Attachment A

Response to Request for Additional Information

13 November 2020

Project	Hills Showground Station Precinct
Drawing Title	Long Section through Doran Drive Precinct and Precinct West
Scale	0 25 75m

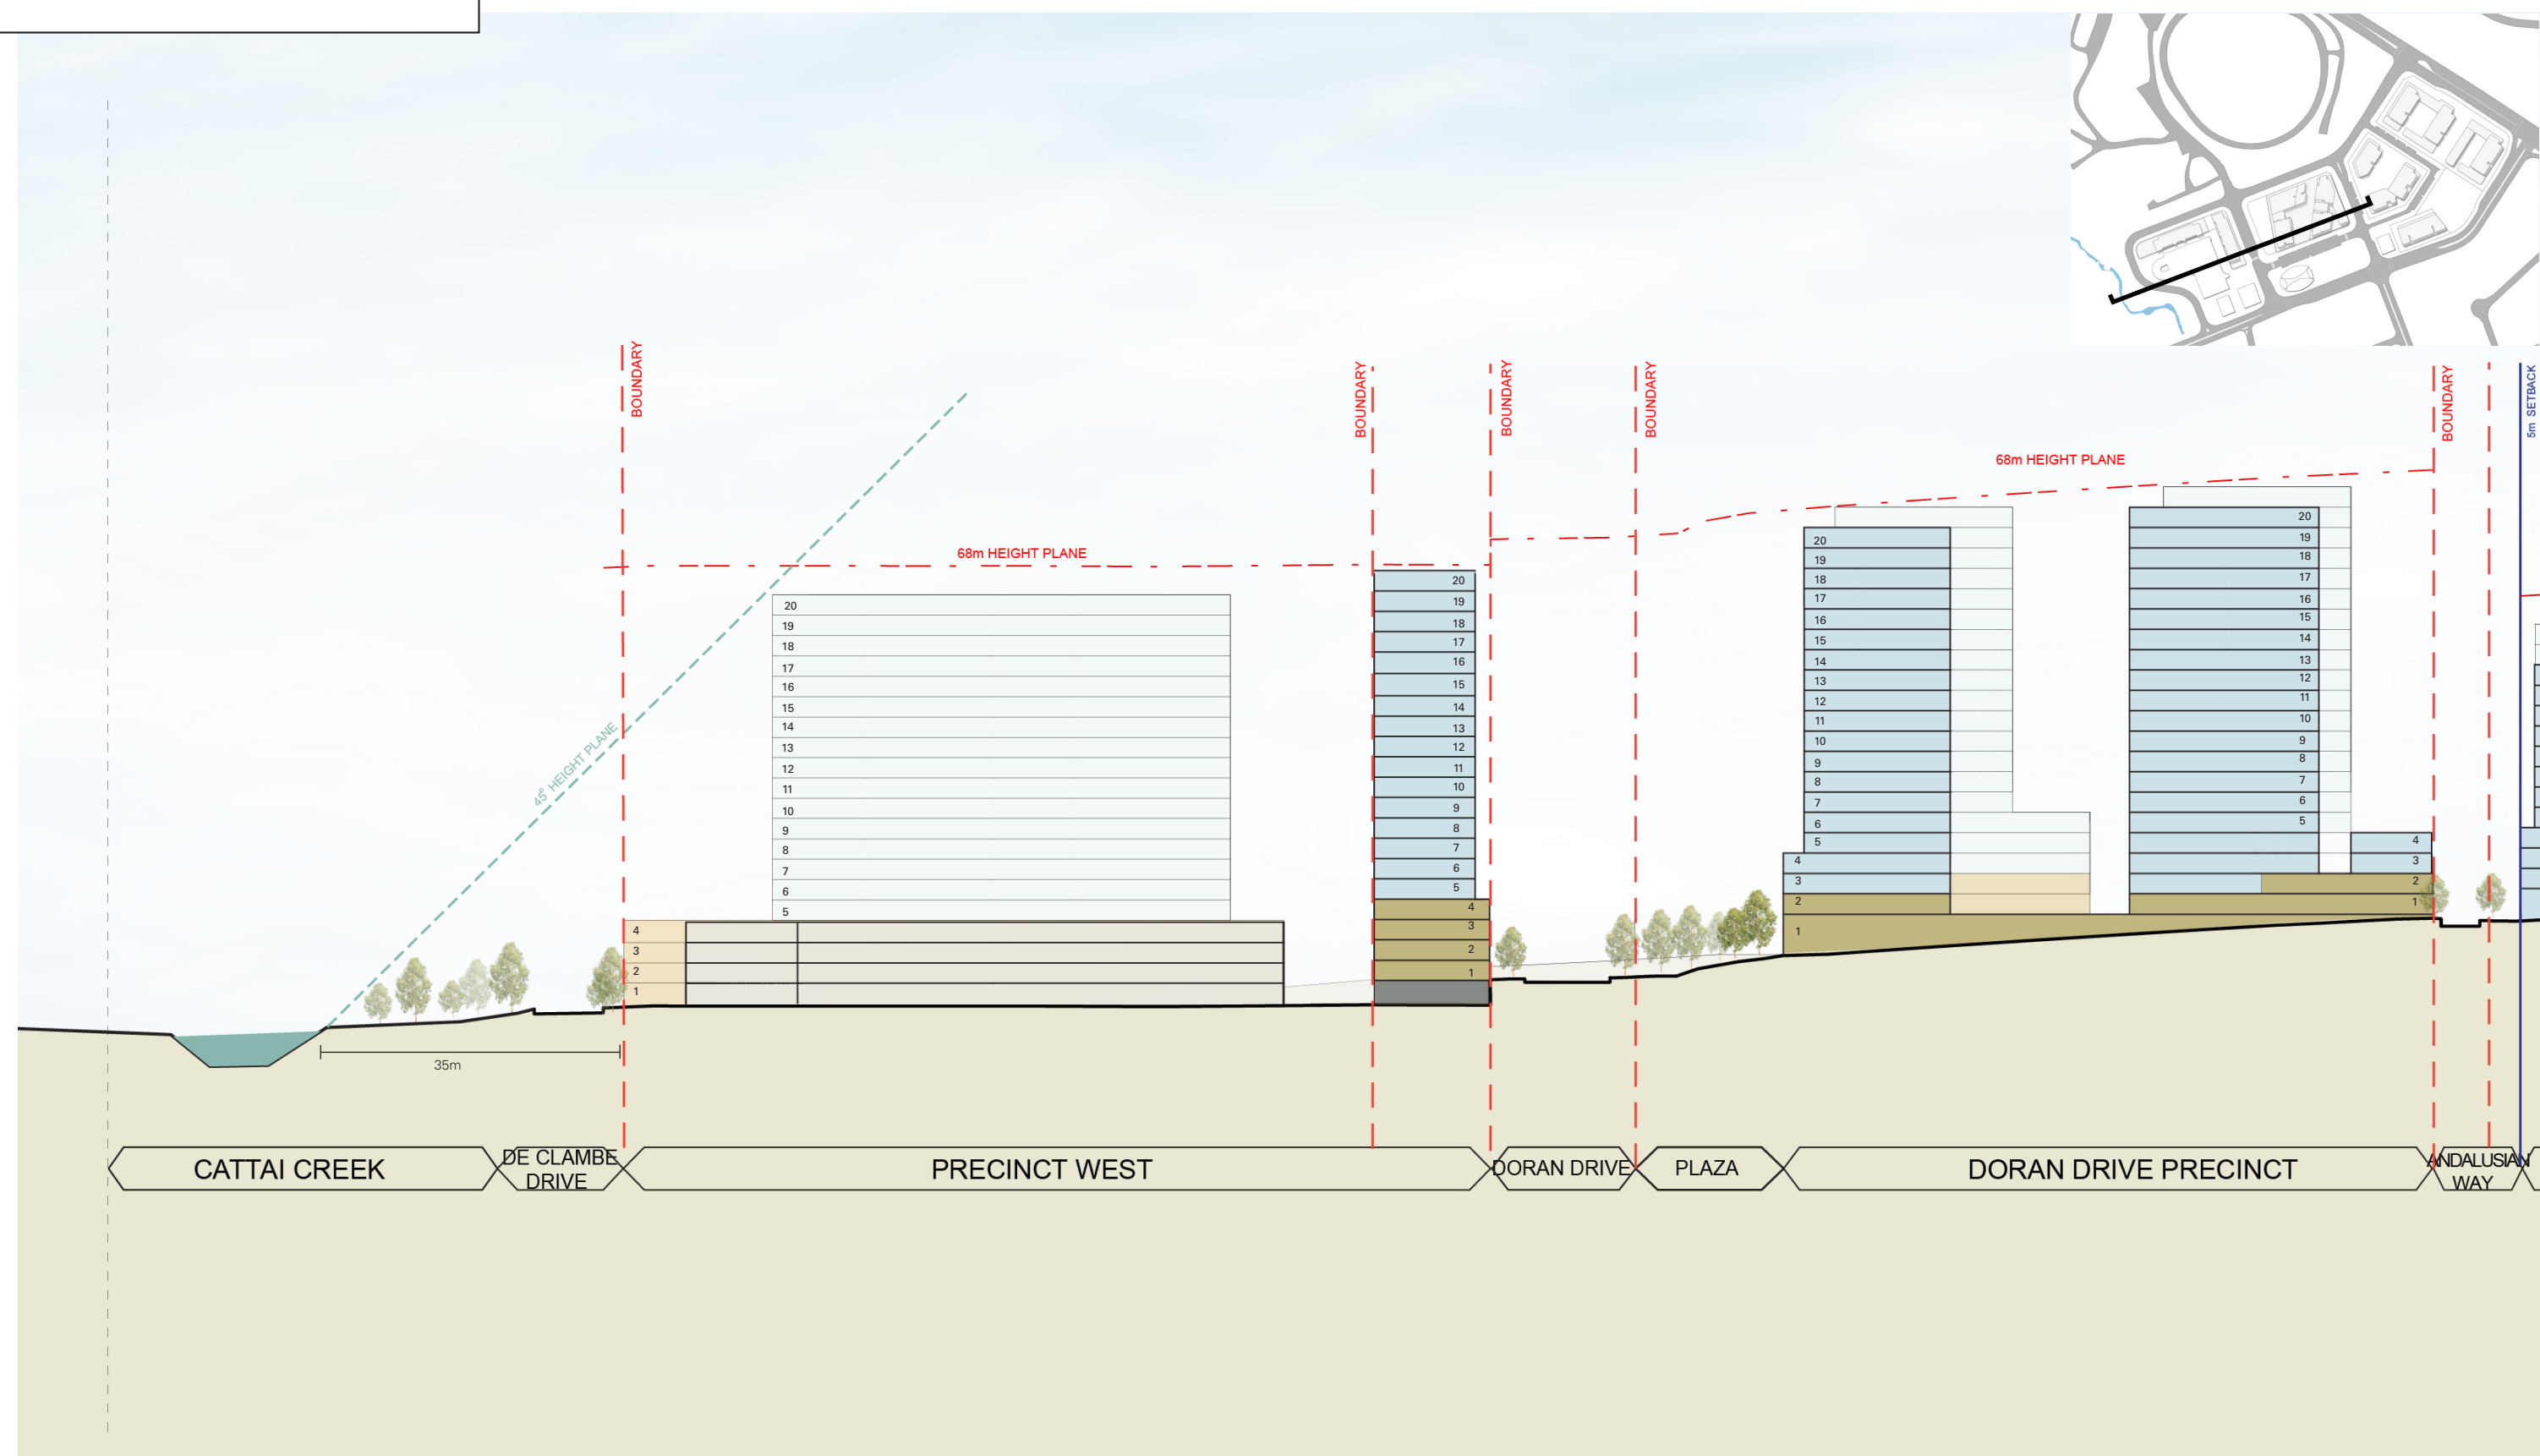
Item	Request for additional Information	Project Response	Annexure Reference
	(ii) Confirm where the top of the bank is measured from in Part 3.2.6 Control 1.	The 35m distance was measured from the distance from the top of bank to the east site boundary for Precinct West, the 45 degrees was converted from the top of bank to a measurable metric as per the revised Urban Design Guidelines under section 3.2.6 – Building Transition.	Annexure B – Urban Design response to RFI – page 12 Annexure C – Urban Design Guidelines – Section 3.2.6
